CITY OF ALBUQUERQUE

March 25, 2026

RE: 3535 Menaul Blvd NE
Grading and Drainage Plan
Engineer's Stamp Date: 03/23/2026
Hydrology File: H16D083F6
Case # HYDR-2026-00108

Based upon the information provided in your submittal received 03/23/2026, the Grading & Drainage Plan is **not** approved for Building Permit. The following comments need to be addressed for approval of the above referenced project:

SHEET NUMBER: C100

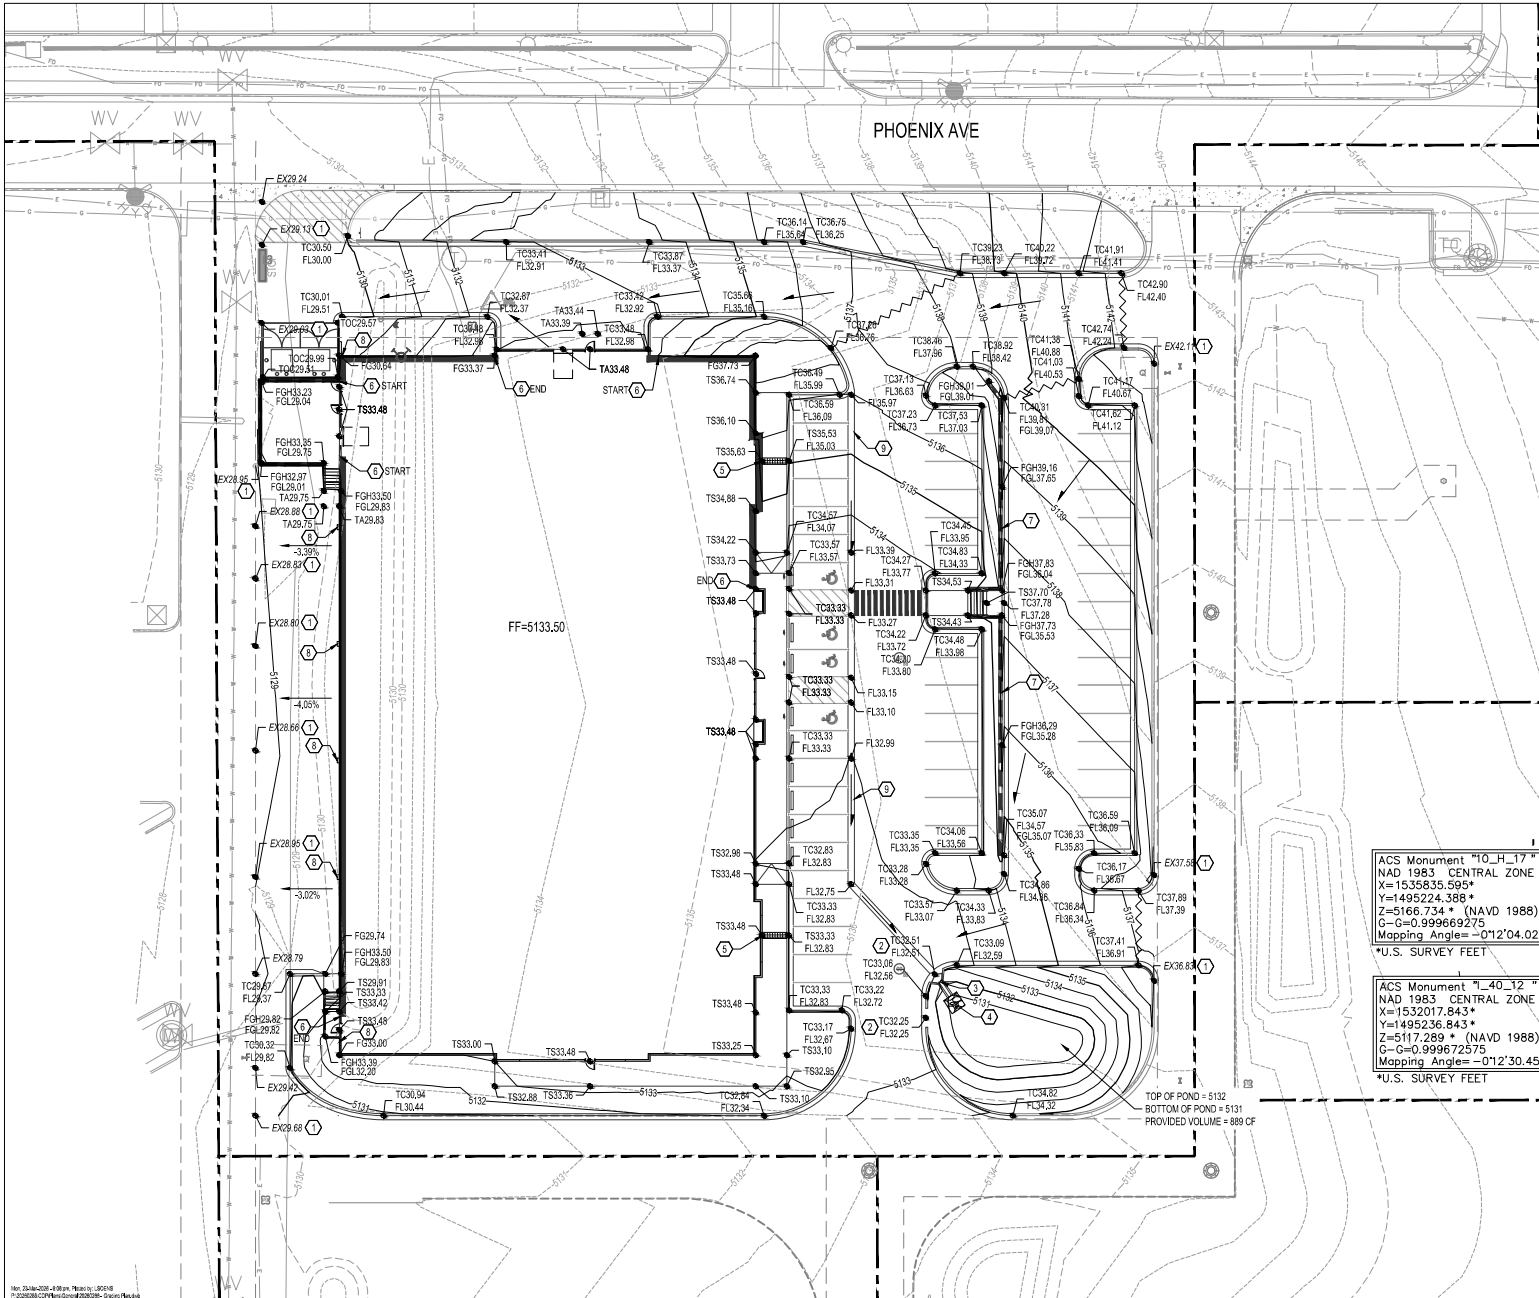
1. Please provide the FIRM Map and flood plain note with effective date.
2. Please provide the Benchmark information (location, description, elevation, and datum) for the survey contour information provided.
3. Payment-In-Lieu – Please submit an Application for Payment-In-Lieu to Hydrology for review and approval. When the request is approved, the payment will need to be made. Per the DPM Section 6-12(C)(1), the Payment-In-Lieu needs to be completed prior to the issuance of a Building Permit.
